Our Ref: R/2017/14/O
File No: 2021/020318
Your Ref: SSD 8517 – MOD 7

Emily Dickson
Senior Planning Officer – Key Sites Assessments
Department of Planning, Industry and Environment

Request for advice – Locomotive Workshop MOD 7 – expand retail uses into Innovation Plaza (SSD 8517)

Drawing Title
PROPOSED ELEVATIONS

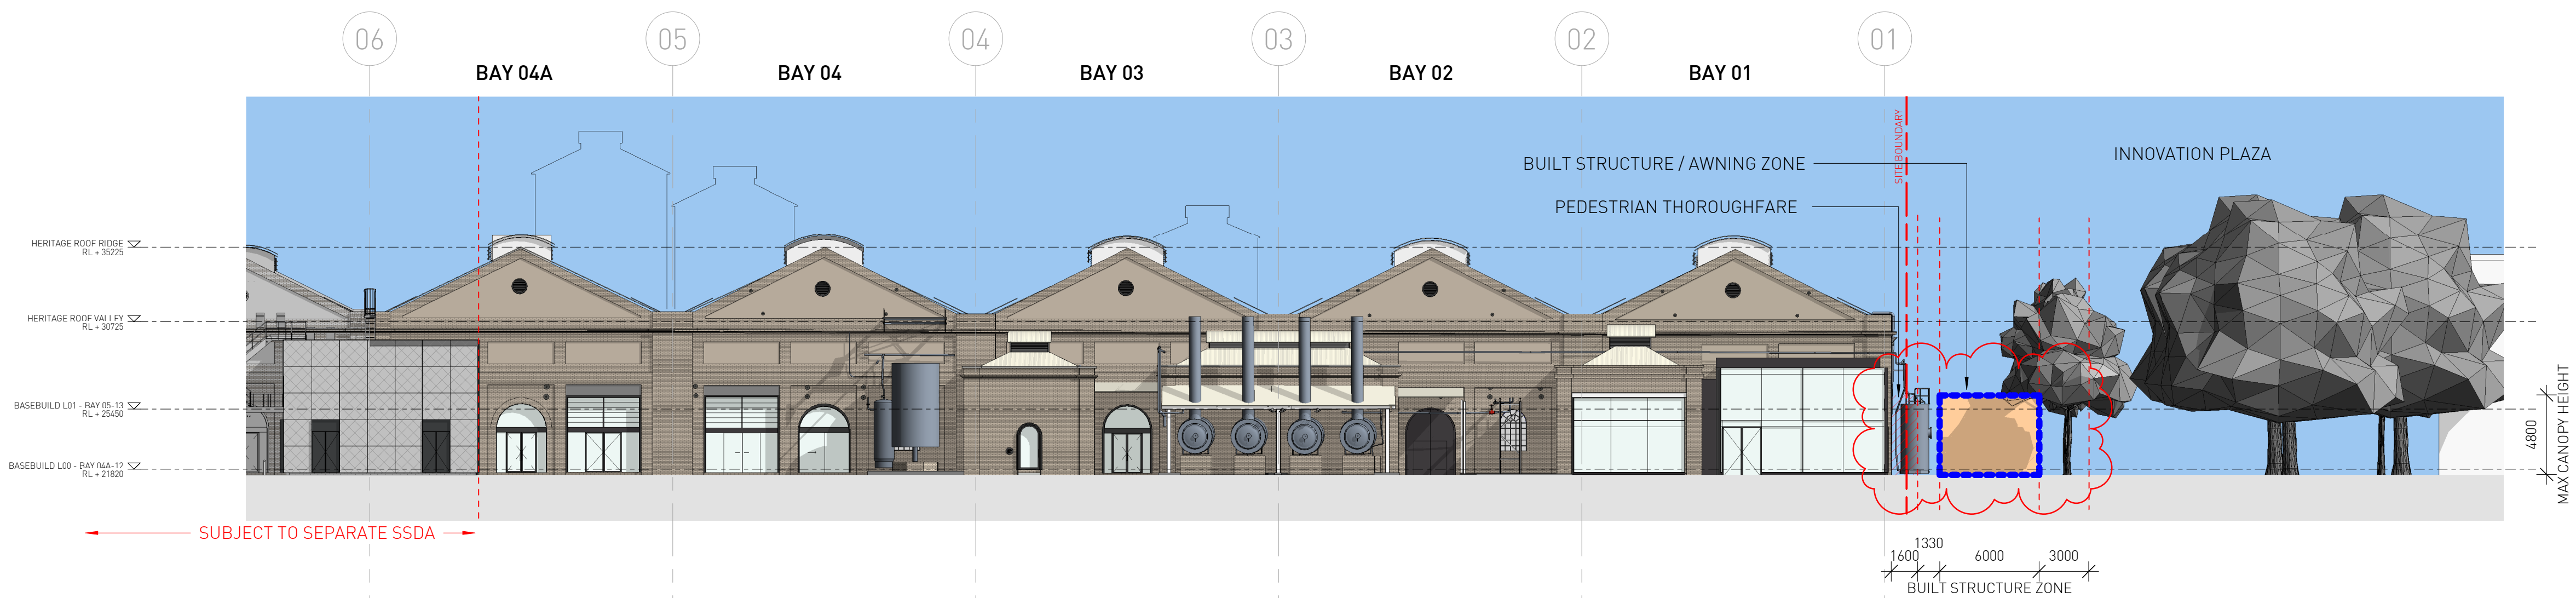
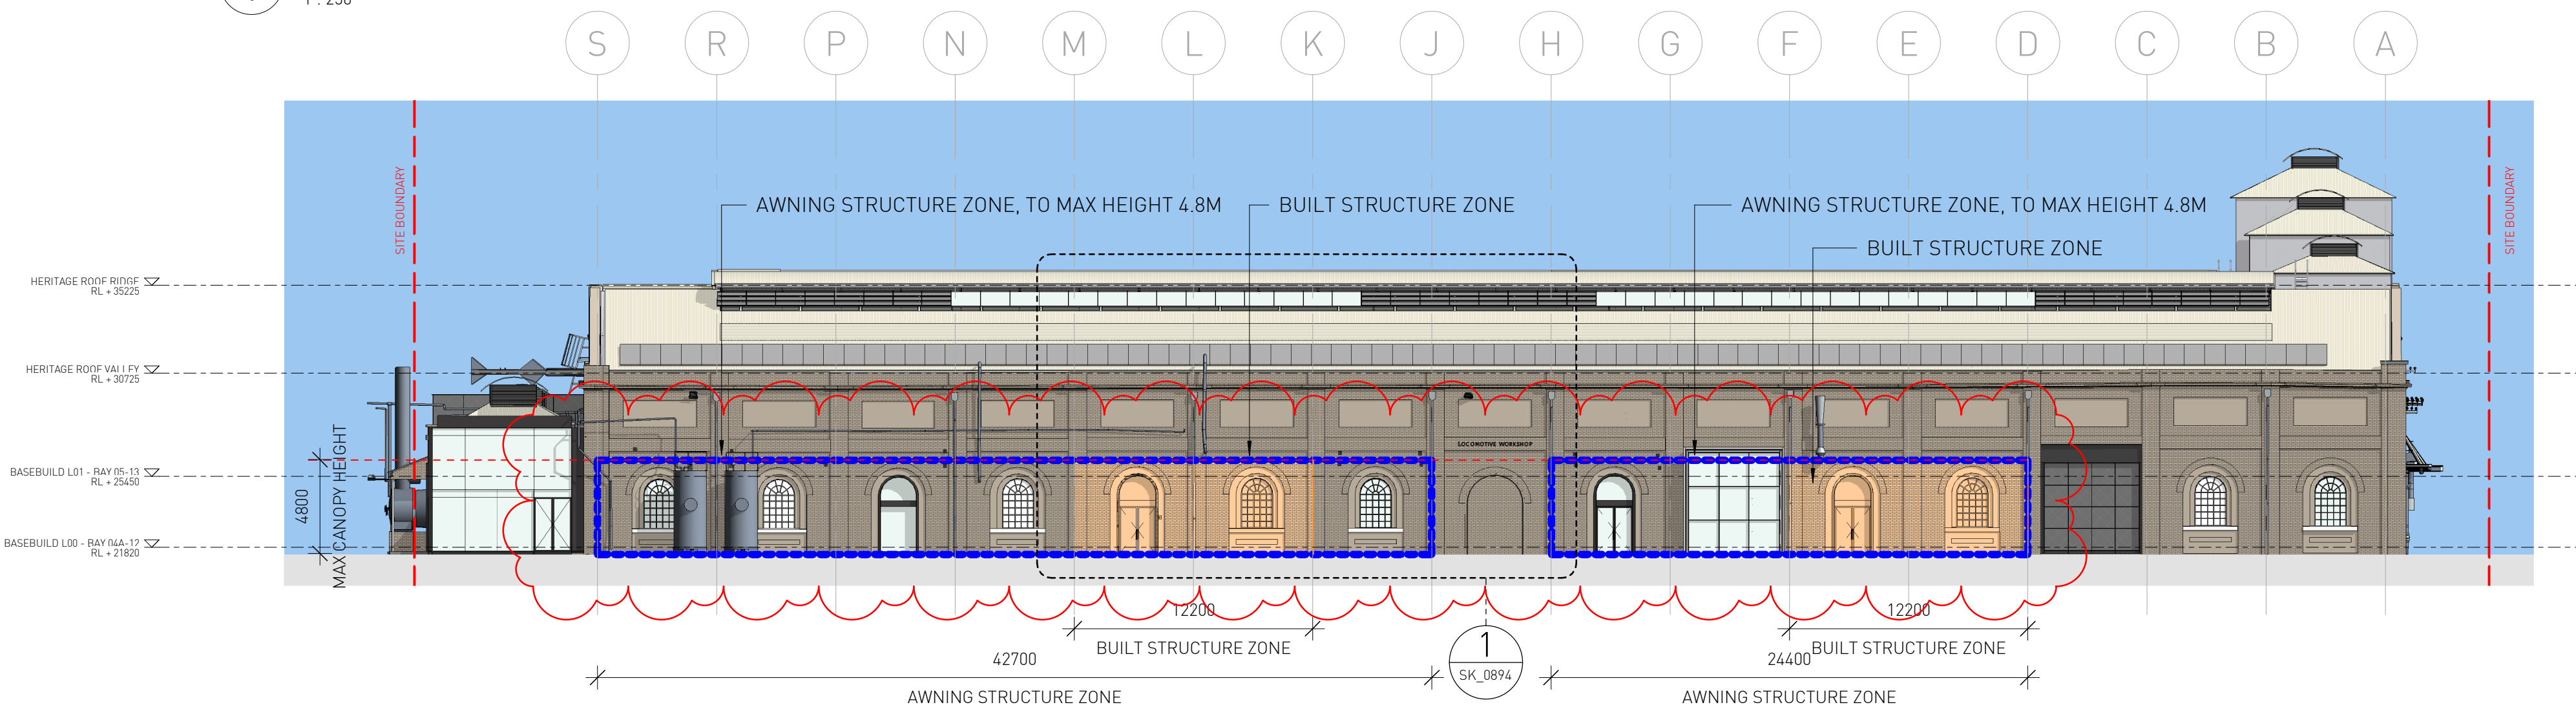
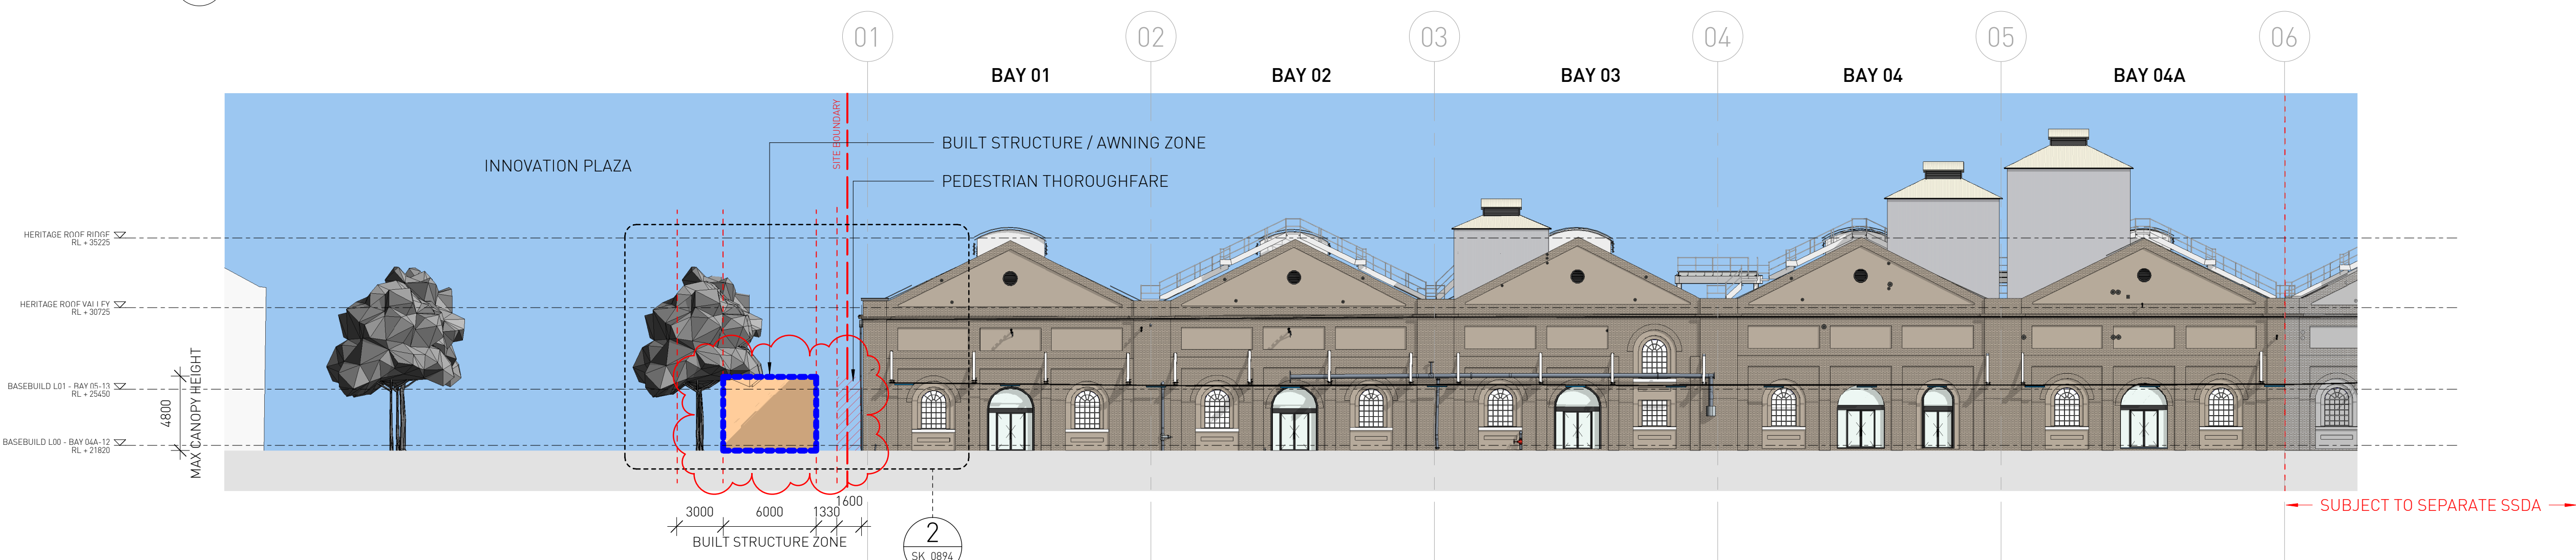
- Having regard to the proposal relating to the provision of outdoor dining zones and building envelope for structures only, it is imperative that any future application for the detailed design be well considered to allow the eastern façade of the Locomotive Workshops to be revealed whilst allowing for the continual functionality of the Plaza for public open space as the primary thoroughfare to and from the ATP precinct. As such, the operating hours of the retail uses, the types and location of the seating and furniture proposed, outdoor lighting and the accessibility through Innovation Plaza and the Locomotive Workshops must be addressed in any future application.
